**From:** [Chad Bala](#)  
**To:** [Kelly Bacon \(CD\)](#); [Jeremy Johnston](#)  
**Cc:** [Dan Carlson](#); [Pat Nicholson](#)  
**Subject:** Sweetwater Response  
**Date:** Monday, June 14, 2021 2:37:45 PM  
**Attachments:** [SwtWtr Resp. 6-14-21.pdf](#)  
[Swtwtr site plan fn16-11-21 Revised plan copy 2.pdf](#)

I hope you all had a great weekend? I am emailing to follow up on the Sweetwater conditional use permit. I have attached two items that meet the needs directly related to our zoom call/conference call regarding this conditional use permit application.

Revised Site Plan
 Submittal Date
 6-11-21

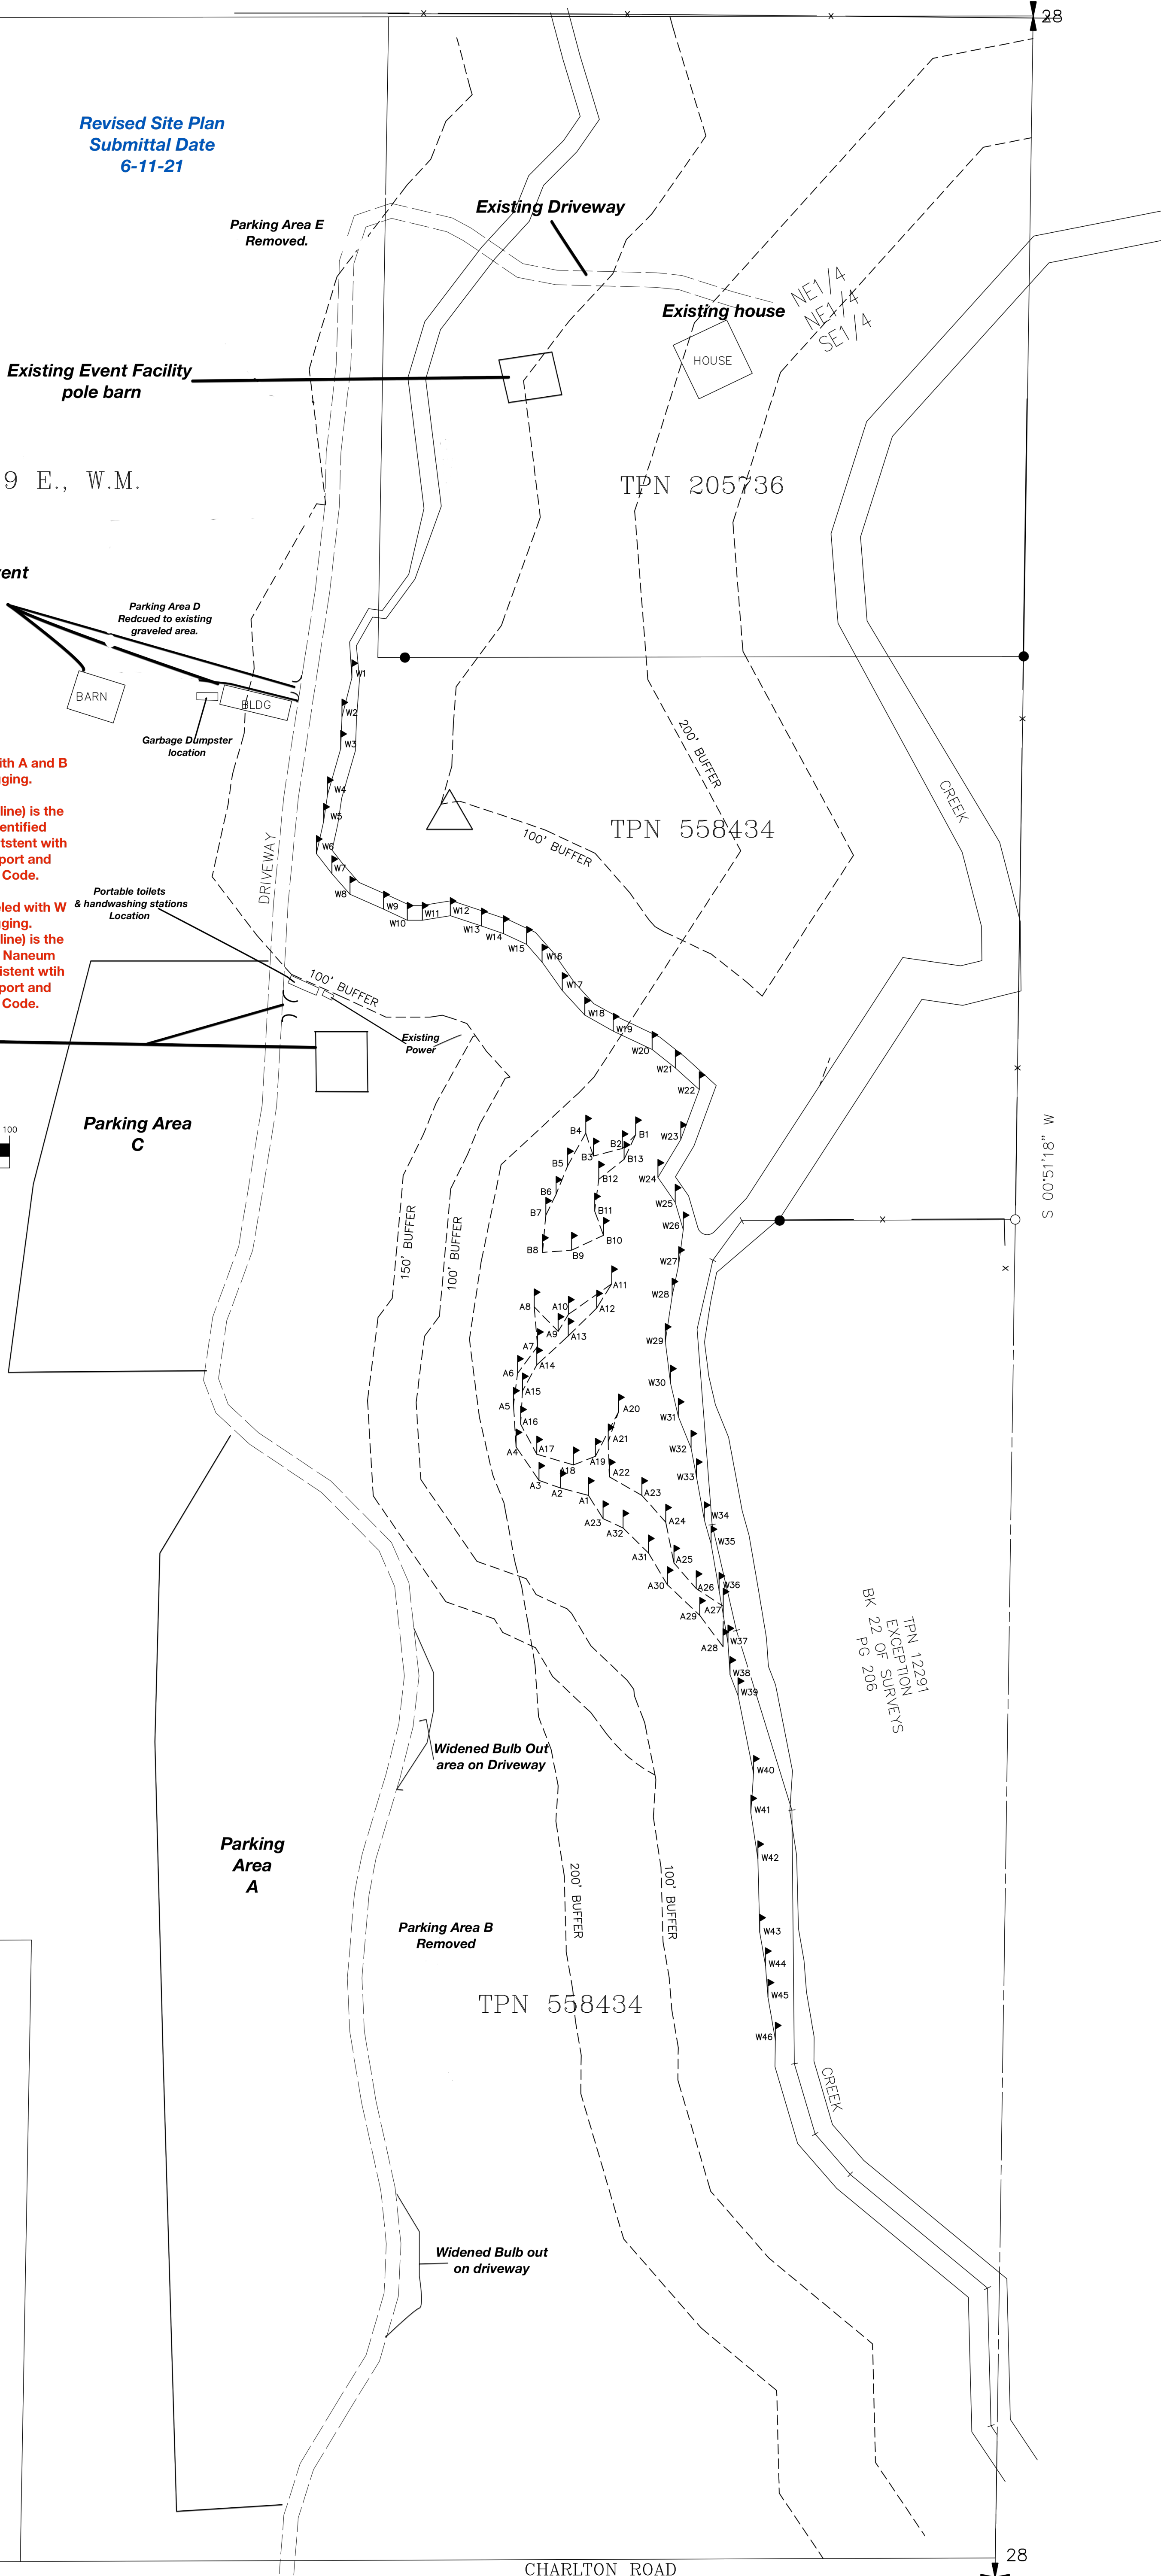
1. Parking Area E has been removed.
2. Parking Area D has been reduced down to the existing gravel parking area associated with the structures and round-pen at that location.
3. Parking Area B has been removed.
4. Driveway (bulb outs) have been added along the driveway per Fire Marshal direction.
